DECISION DELEGATED TO HEAD OF PLANNING

Application No: H12-0519-26 **Applicant:** Mr & Mrs K Schwarz

Proposal: Proposed Pitched Roofed Single Storey Extensions to Front & Rear of Existing Dwelling, Detached Single Storey Flat Roof Swimming Pool in Rear Garden

Location: Harecroft Lutton Bank Lutton

Drawing
FIRST FLOOR PLAN & ELEVATIONS
AS PROPOSED

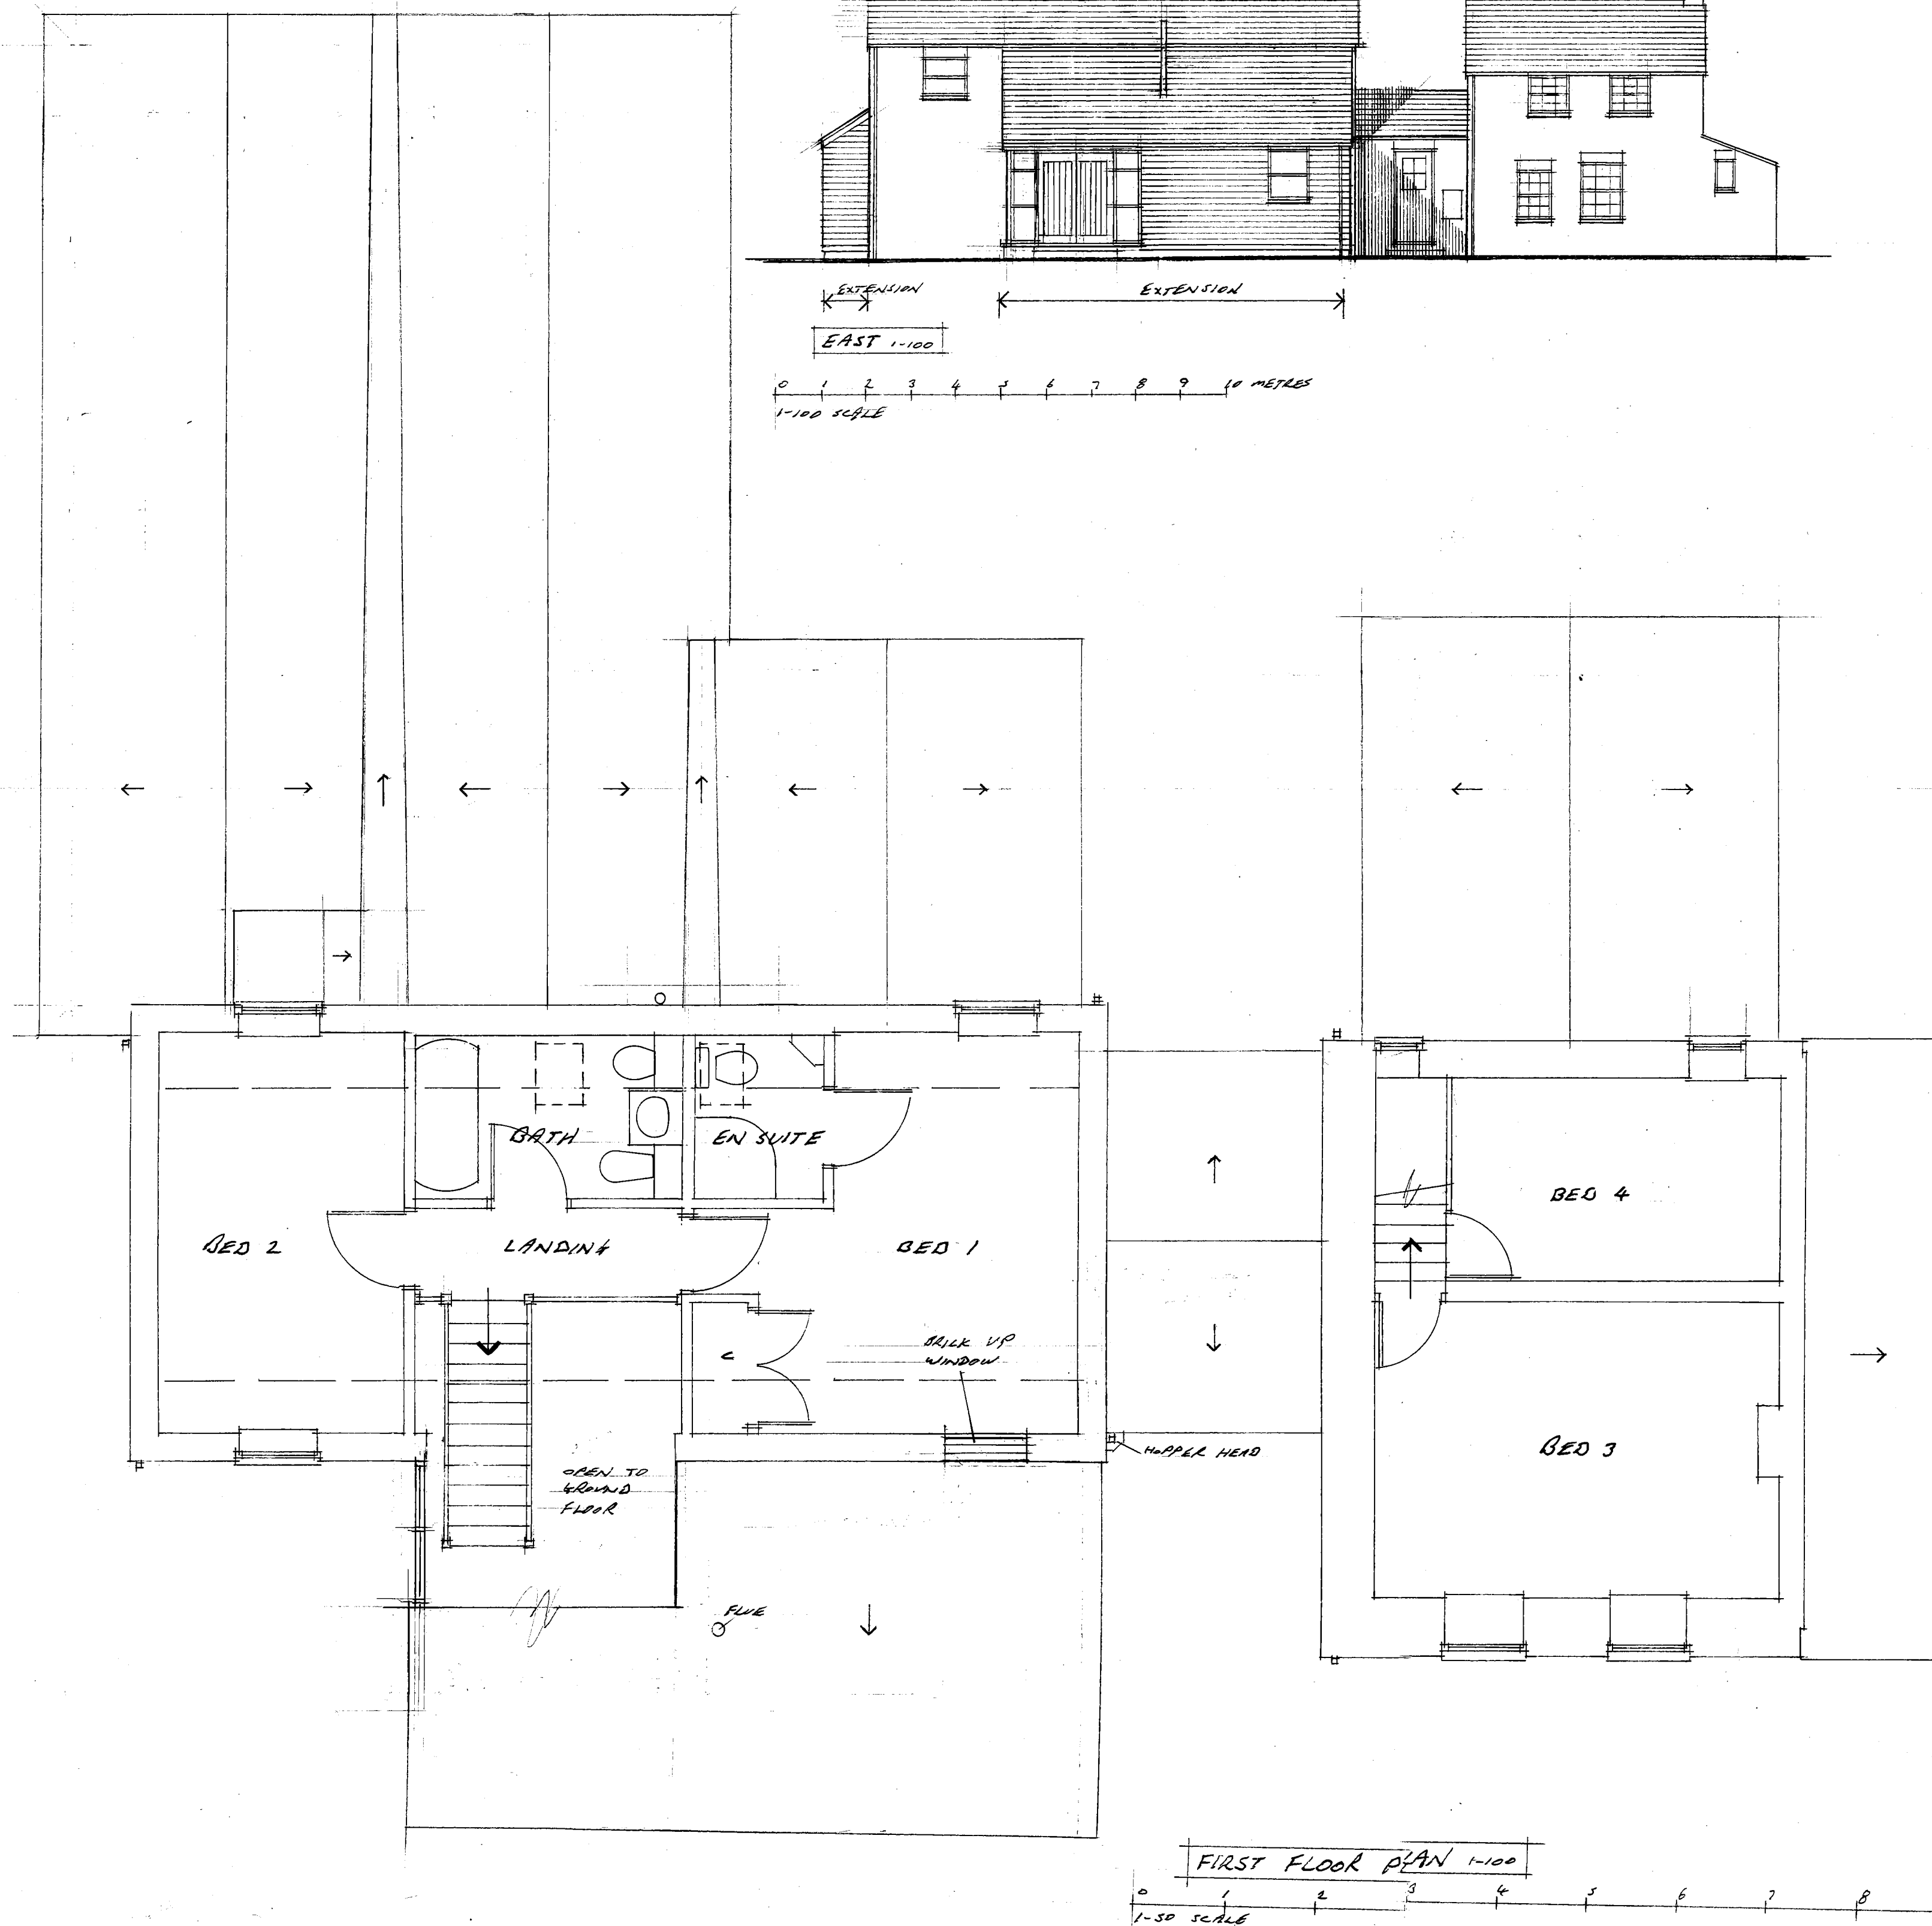
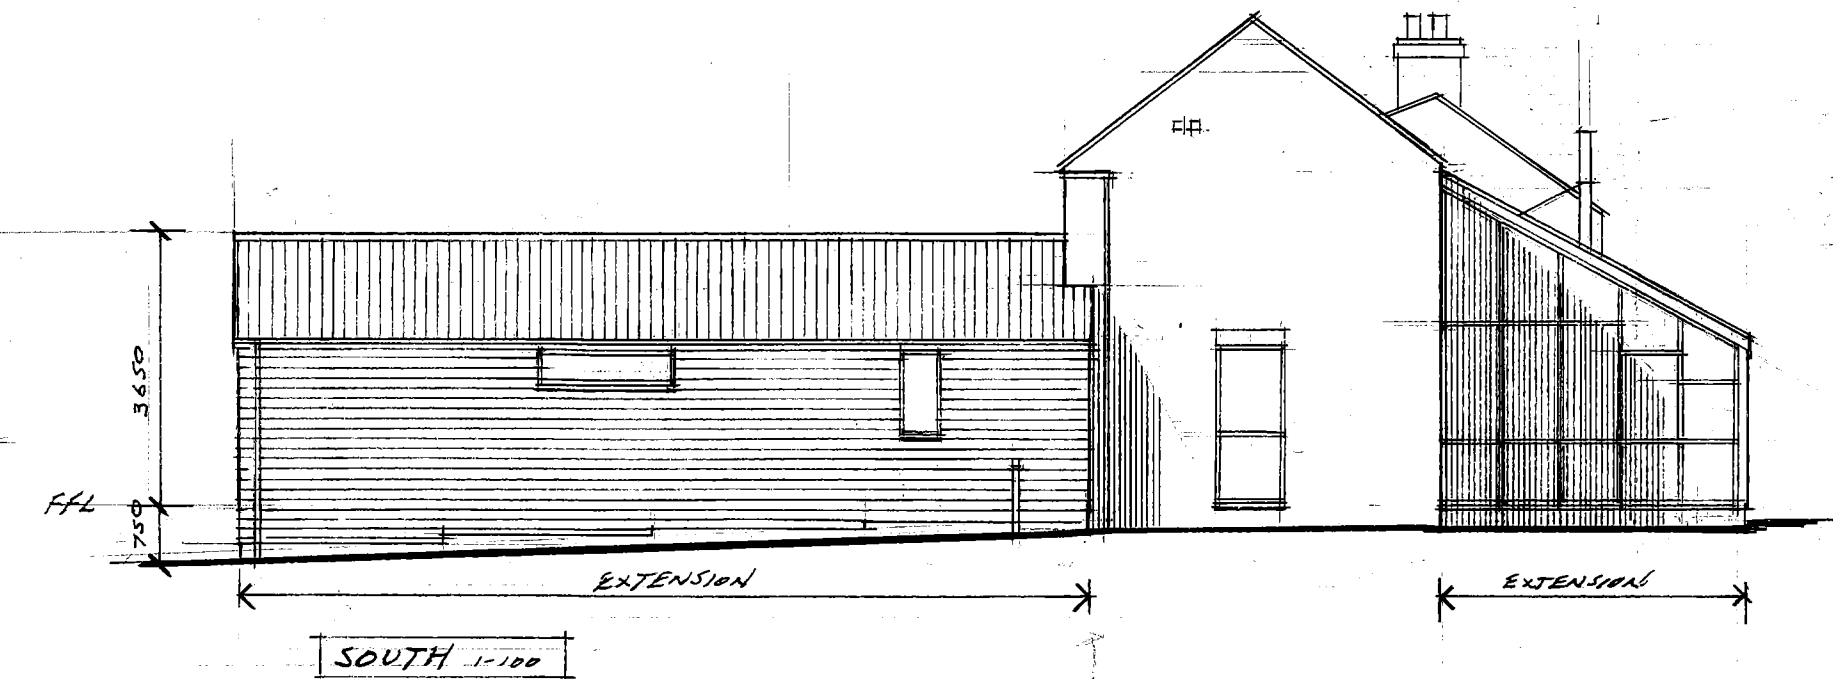
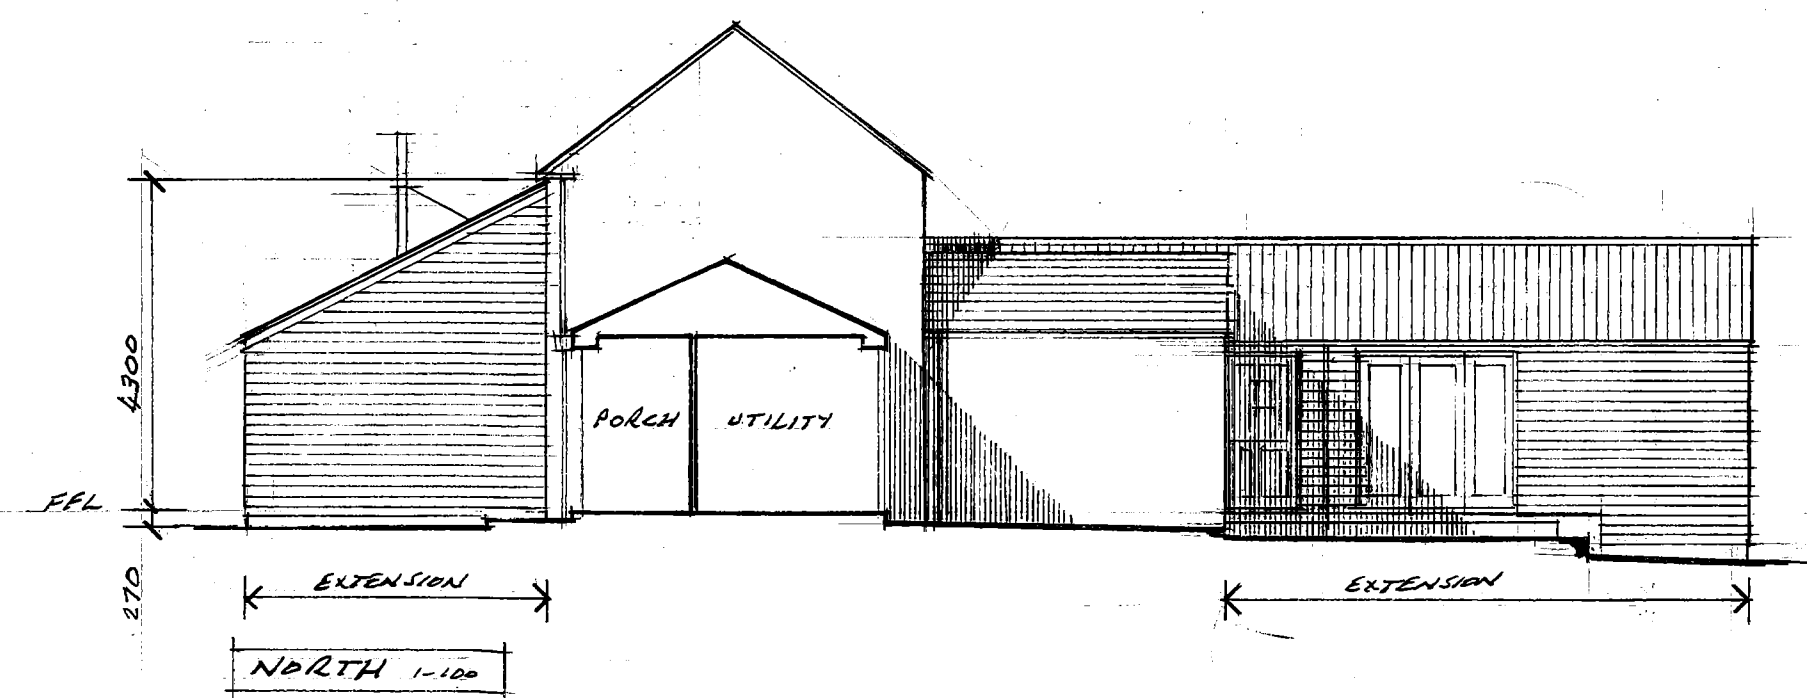
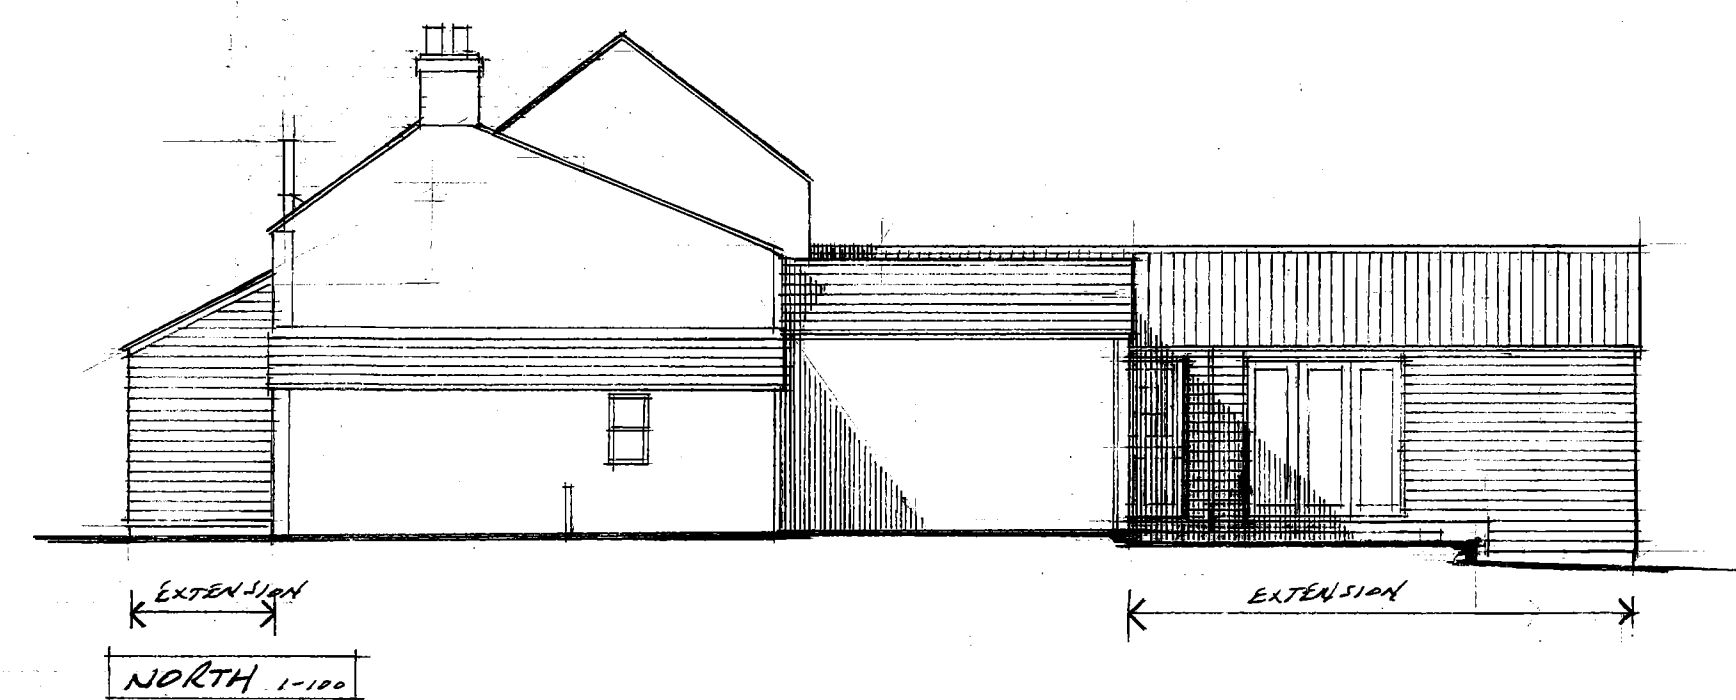
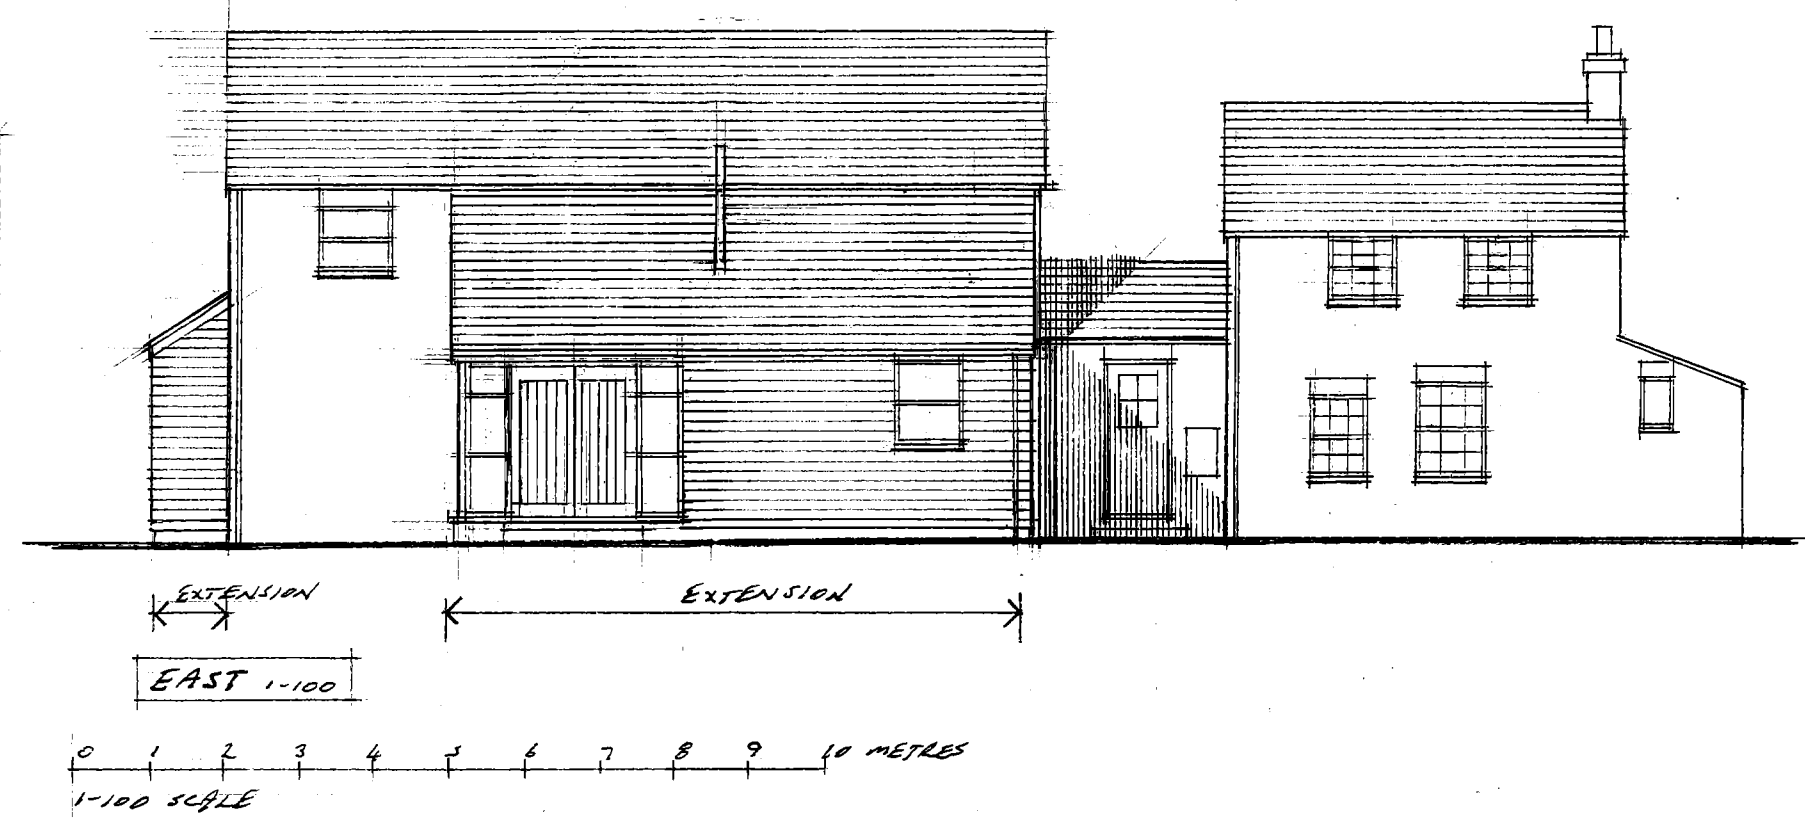
Shiplap, or comparable, cladding is commonplace on agricultural/ rural buildings throughout the District. However, it is not extensively featured in the immediate area (i.e., Luton Bank) making it a slight oddity in the area. Moreover, whilst this material may be reminiscent of agricultural buildings, it is not typical of residential dwellings in the area. The colour proposed (grey/ silver) would be highly unusual in the setting. Black shiplap cladding is a more commonplace material, however, variations of this, including grey are not typical, particularly in this setting. The material would clearly juxtapose the palette of the wider area. As a result, there would be a degree of juxtaposition with the immediate area which is more domestic in character. The proposal would therefore fail to accord with Paragraph 57 of the National Design Guide with respect of materials.

The proposed slate to the front would be consistent with the wider dwelling, helping to integrate the extension with the host. The rear clay pantiles would juxtapose the materials of the host to a certain extent, reducing the integration of this element with the host.

The rear extension would be partially obscured from the public realm by the existing buildings; however, it would not be entirely obscured. In particular, an element projects beyond the side elevation of the existing building. This provides an awkward relationship which fails to respect the existing proportions of the dwelling, whilst also reducing the integration of the extension with the host.

The rear extension is relatively large. It is considered that it fails to reflect the existing proportions of the host dwelling, or the built form of the wider area, resulting in an overly large dwelling which fails to respect the character and appearance of the area. Moreover, the height of the extension would mean that views from the public realm could be obtained from the road heading to south-to-north.

Due to the significant length of this extension, when these views are obtained, the visual mass of the building would be significant, and significantly at odds with the wider built form. In this regard, it should also be noted that the portion of the house to be extended is itself an extended area. Cumulatively, when these existing and proposed extensions are taken together, they far exceed the scale of the original dwelling, and would therefore fail to produce an adequate subservient relationship.

Whilst the provisions of the submitted justification statement, with regards to the front extension and the inspiration drawn from agricultural lean-to extensions, it is not considered that this element would be in keeping with the area. Front extensions of this nature are uncommon in the area, and so a large catslide roof, projecting significantly from the dwellinghouse, would be an oddity in the area. The proposal would therefore fail to follow the guidance of the National Design Guide with regards to design of the development being influenced by the existing built form.
